LSC Responses to EPC
 PCD TIS Redline Comments

Cottages at Mesa Ridge¹
 Traffic Impact Analysis
 (LSC #S214580)
 January 17, 2022

**WAHATOYA POINT - TYPICAL SECTION - 5
(PRIVATE DRIVEWAY)**

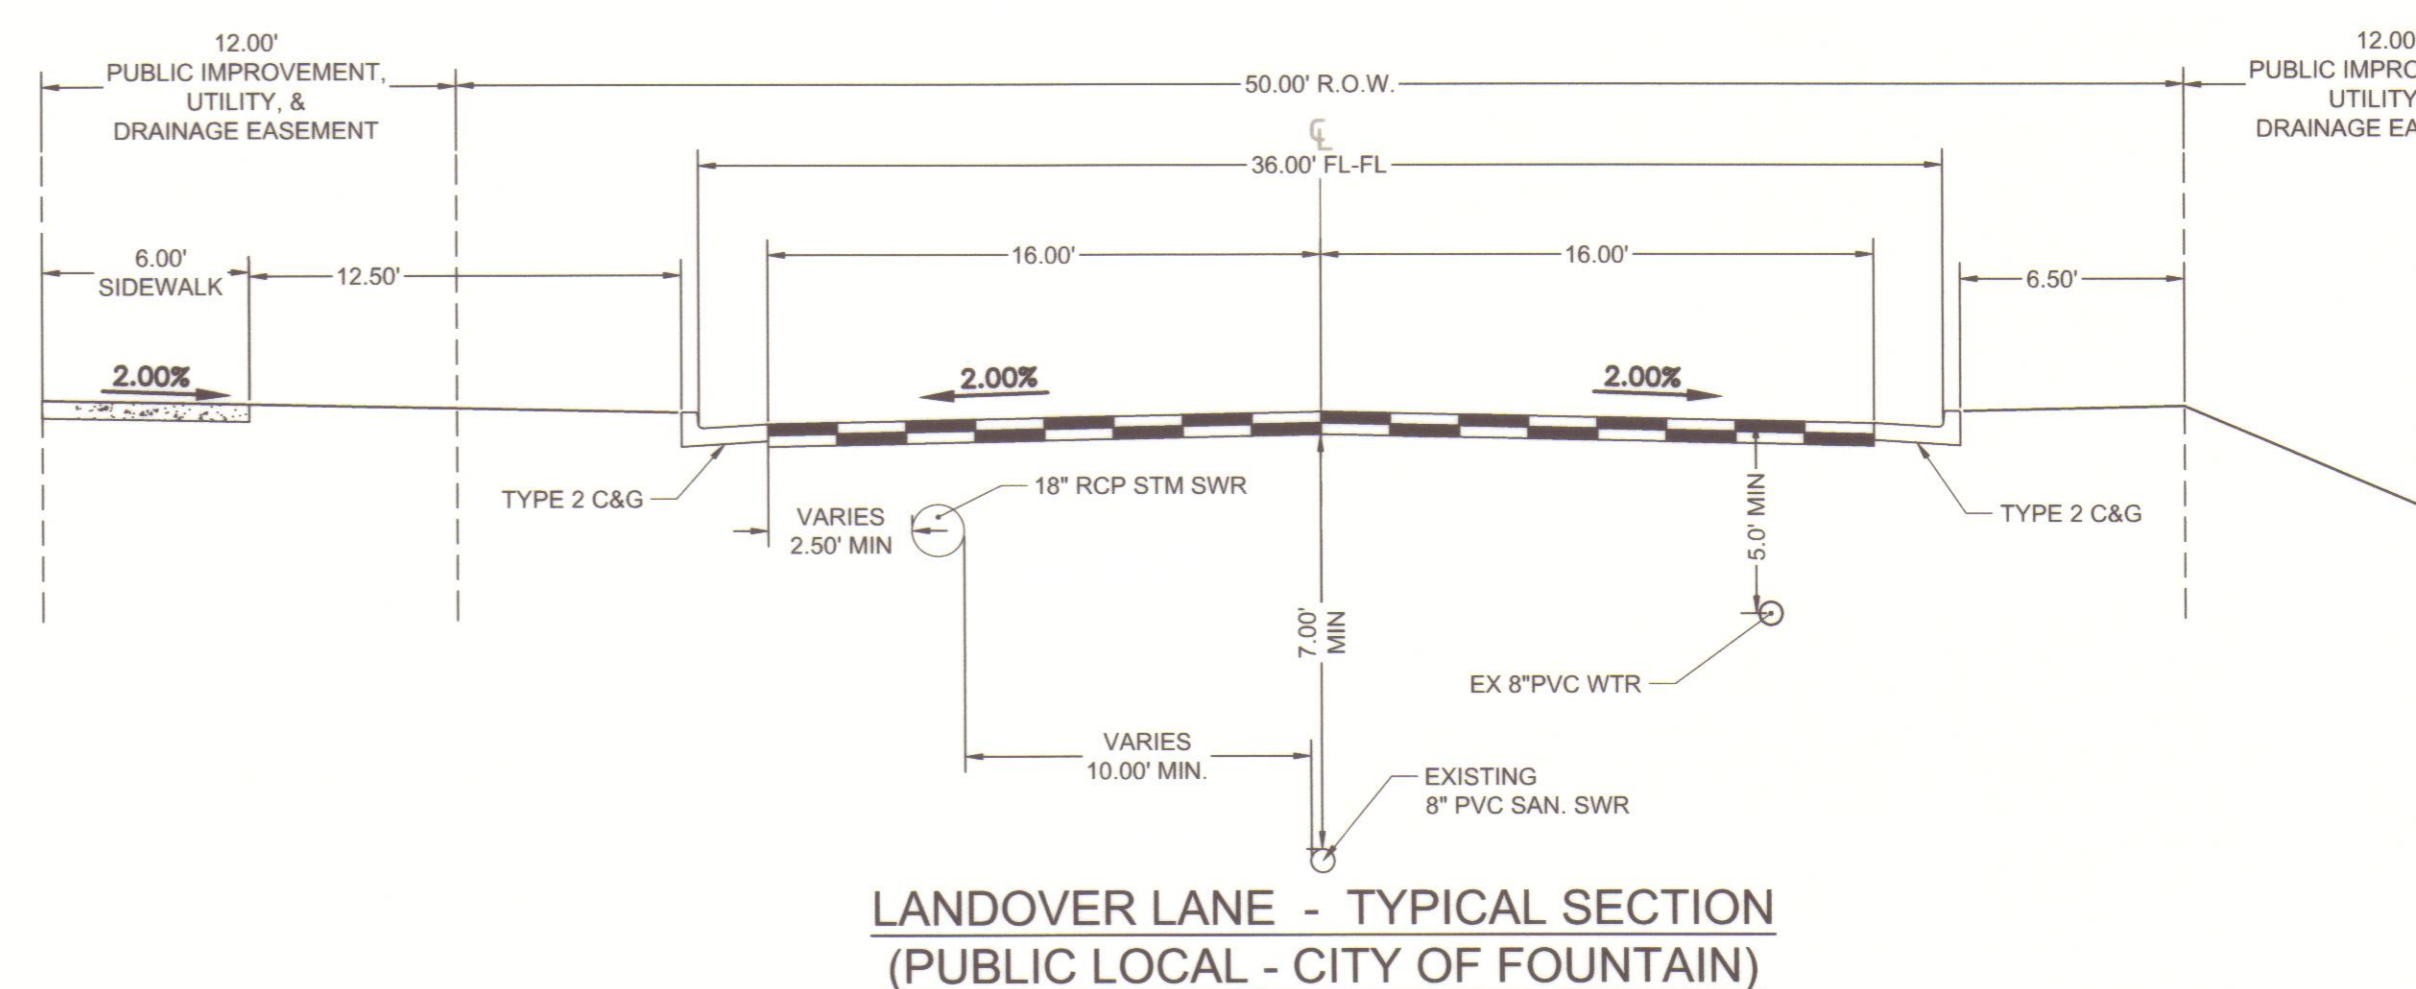
³
Please revise this to indicate private driveways/drive aisles to match what is proposed on the preliminary plan.

Please revise this to indicate private driveways/drive aisles to match what is proposed on the preliminary plan.

LSC Response: Revised as requested.
